**From:** Paul Cann  
**Sent:** 04 October 2017 11:42  
**To:** Planning.Responses  
**Subject:** RE: Planning Consultation on: BR/229/17/PL

**APPLICATION NO: BR/229/17/PL**

**Site Address:** Land to rear of 41 - 47 Pevensey Road Bognor Regis PO21 5NY

**Description of Works:** Erection of 4 No. dwellings, 1 No. detached garage, parking & alterations to existing access & driveway (resubmission following BR/200/16/PL).

DRAWING TITLE
Block & Location Plans and Site Section

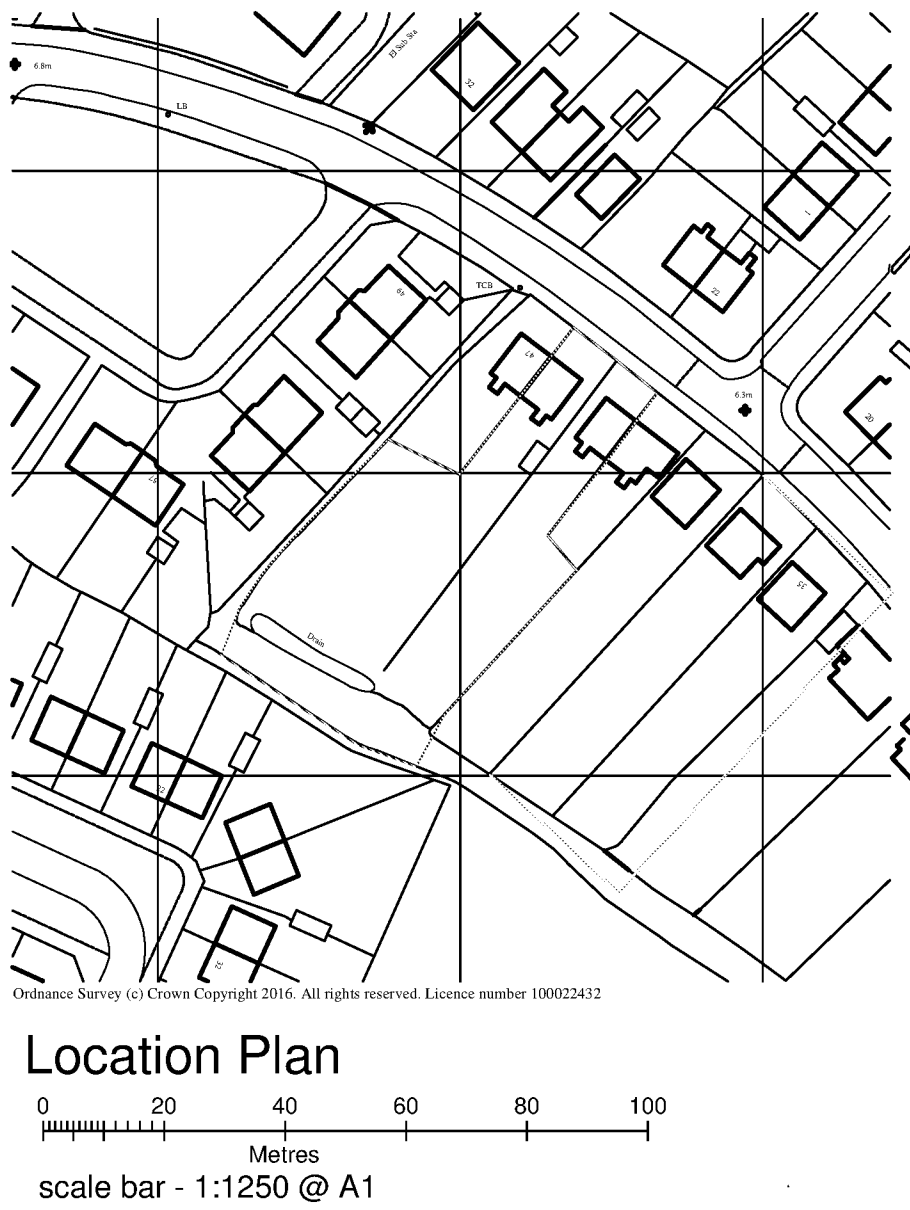
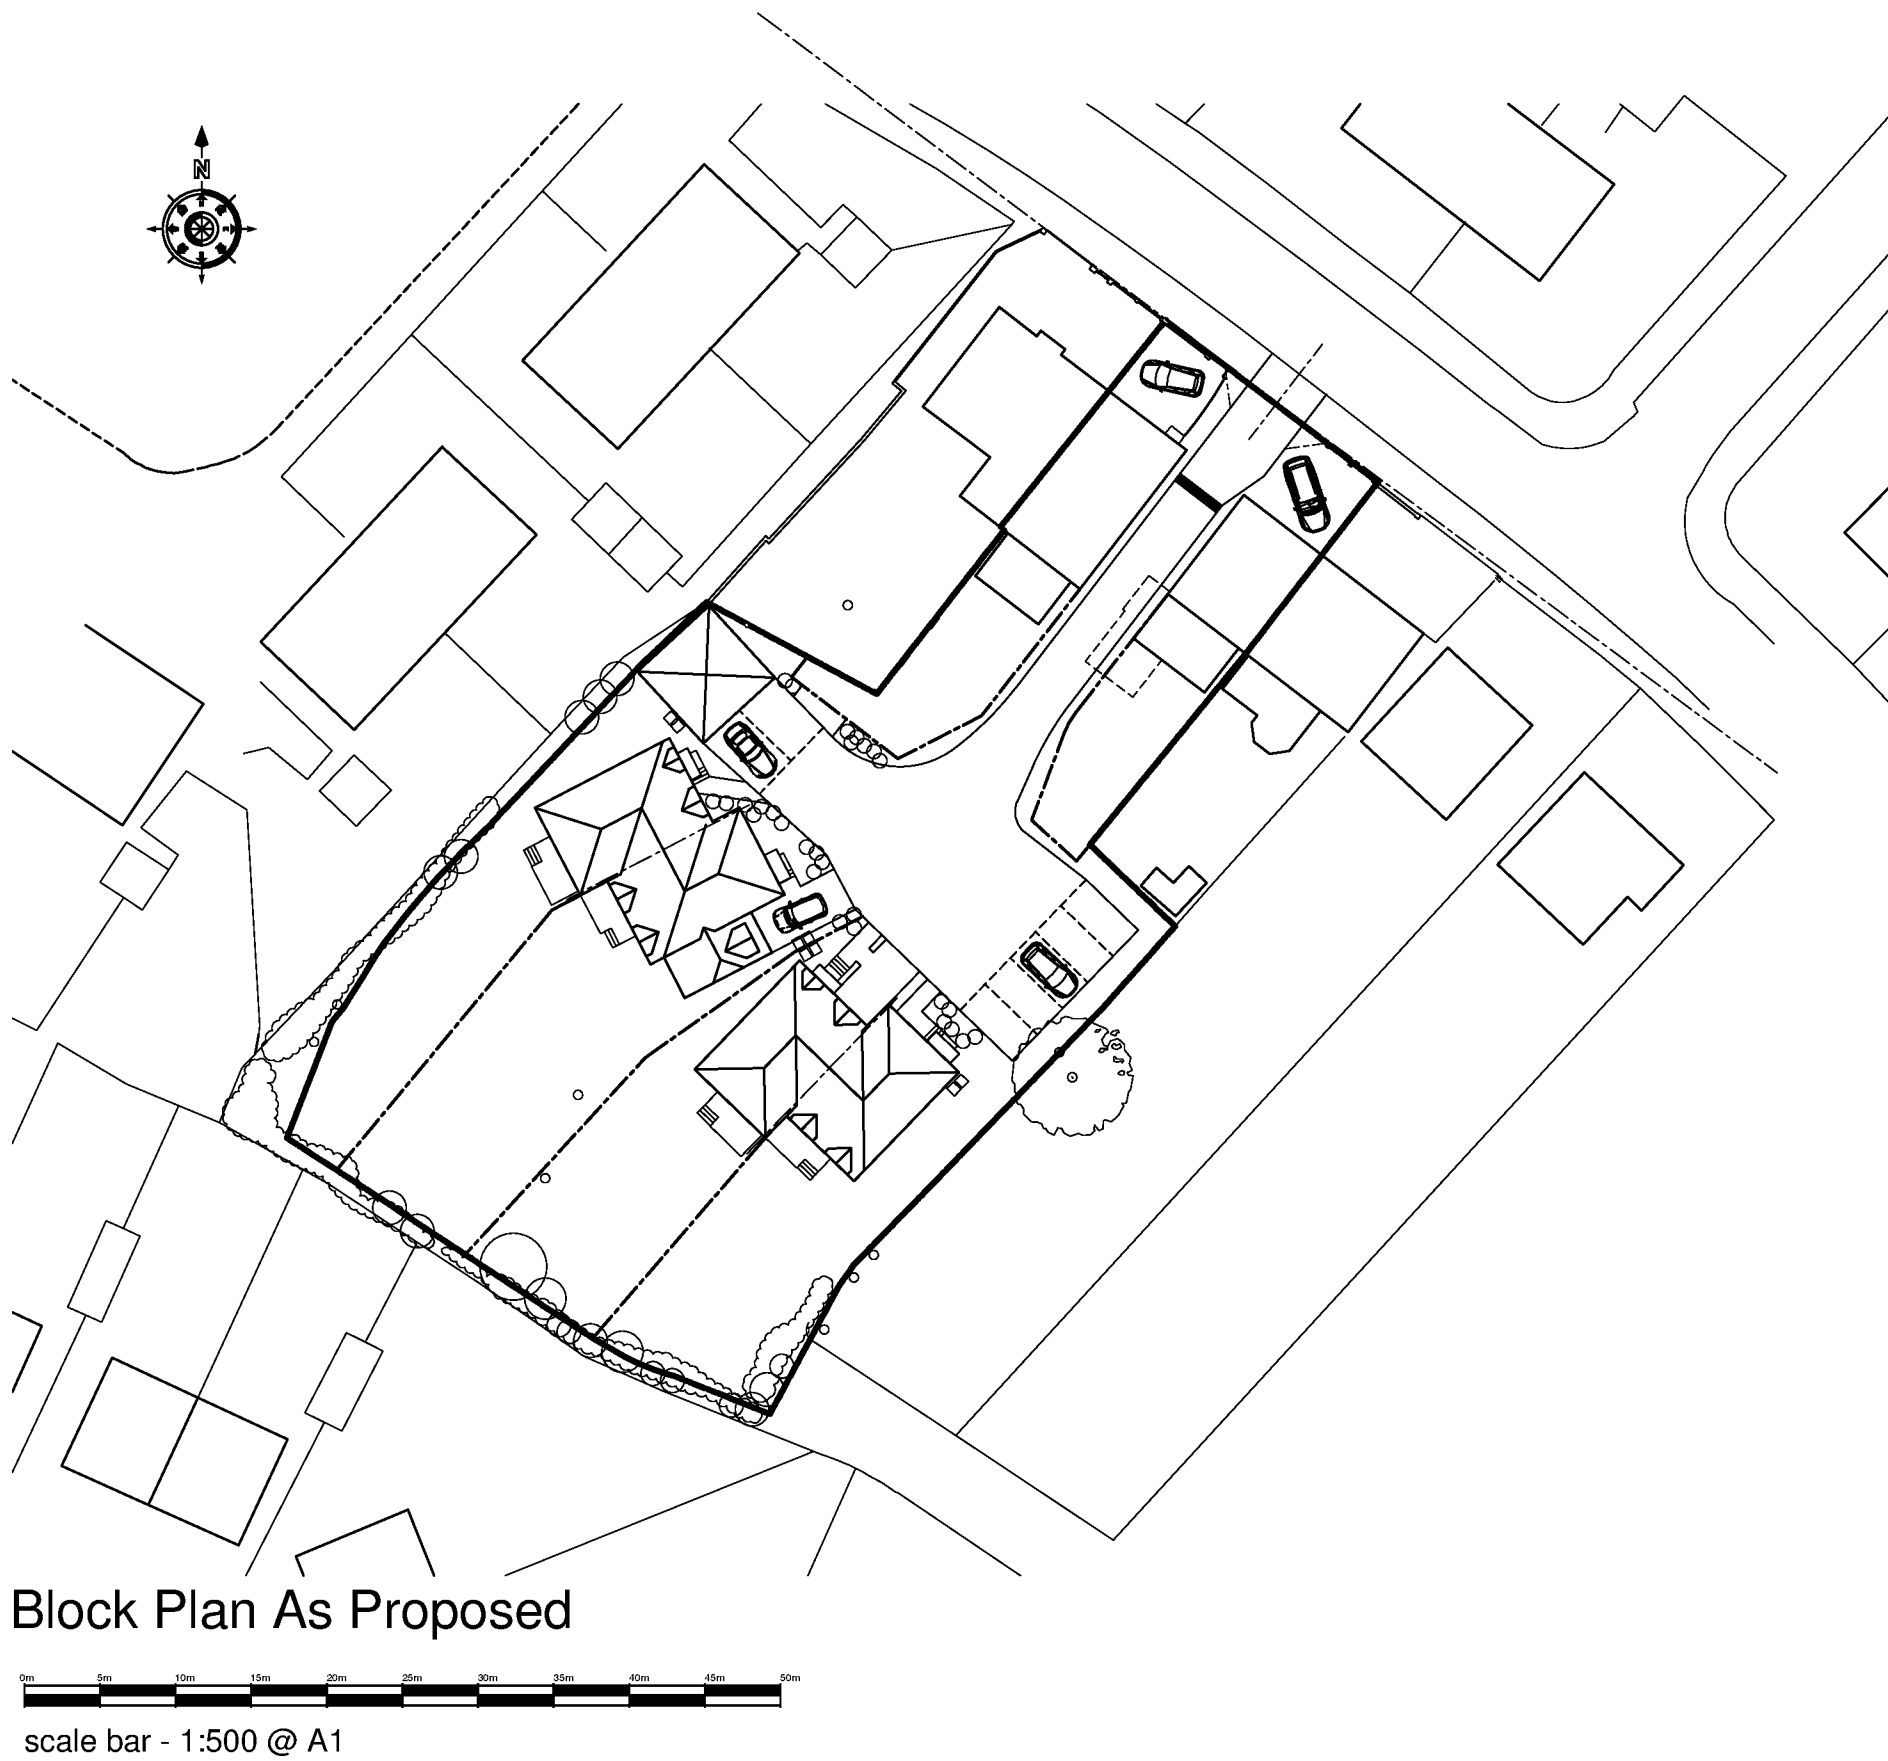
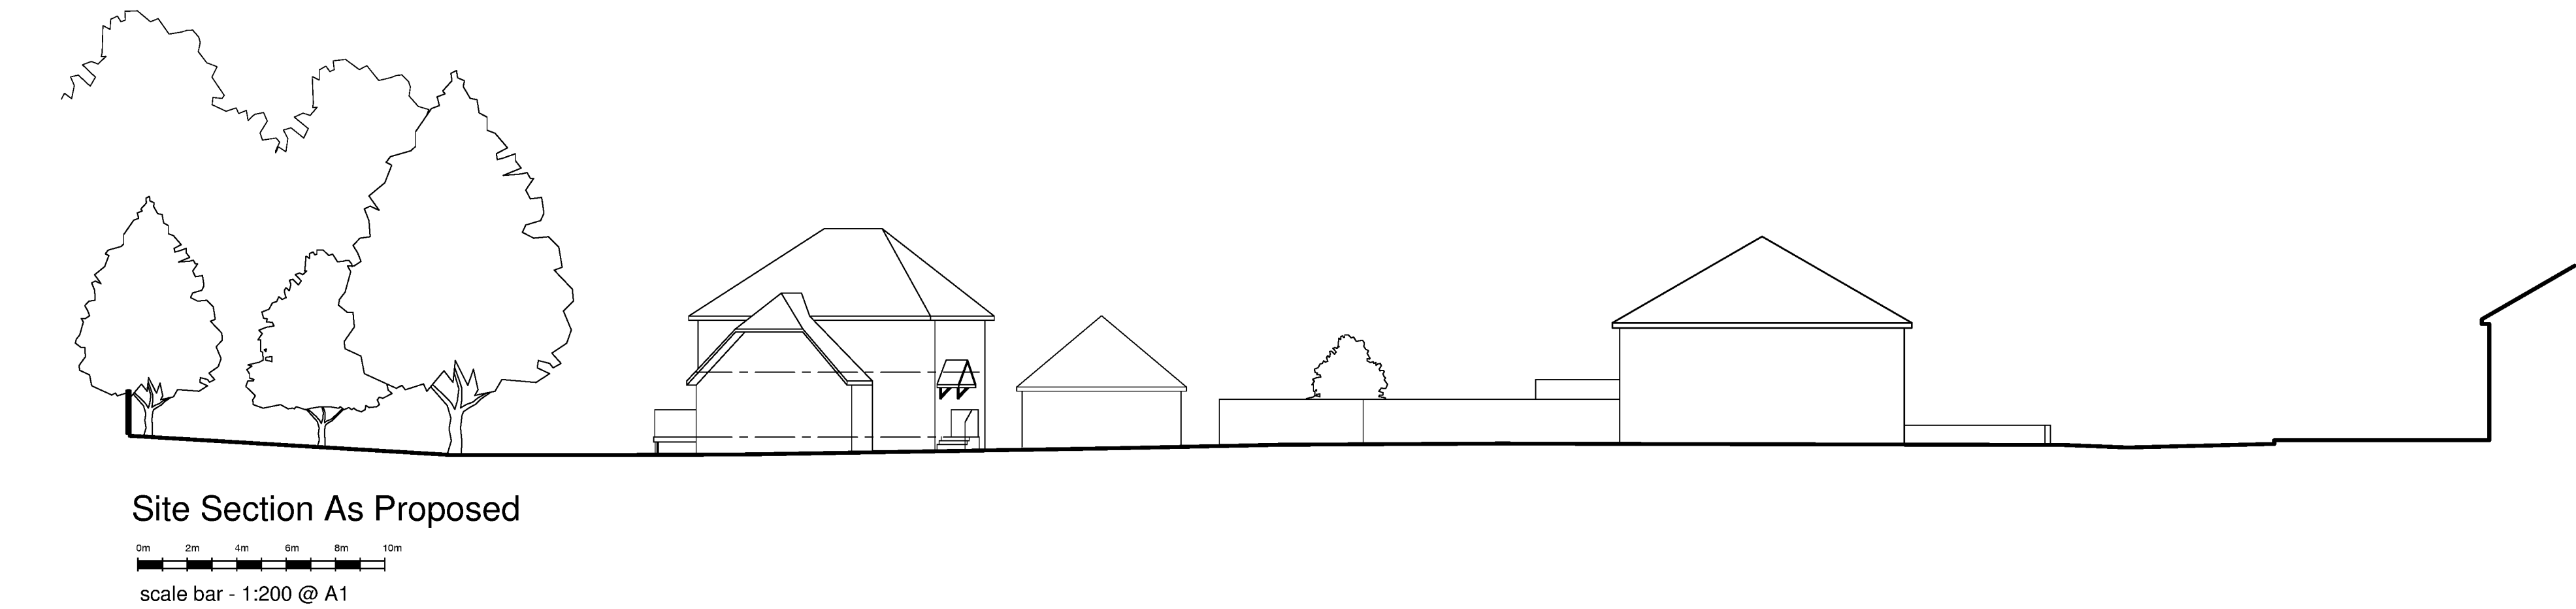
On that basis, I would like to raise an objection to the proposal, until such time that it can be proven that flood risk to neighbouring properties will not be increased. Any raising of ground levels and placing of structures within the flood zone will increase the flood risk. Existing flood storage and flow paths must be maintained (and betterment provided where possible).

A culverted watercourse crosses the site, near to the southern boundary. No new trees to be planted within the vicinity of the pipe and all boundary fences will need to be demountable with fence posts not being positioned above the pipe. The detailed arrangements will need to be agreed. There are remnants of the original ditch that once passed through the site, which represents the lowest area within the site. This must be retained/cleaned out as it provides local drainage/flood storage.
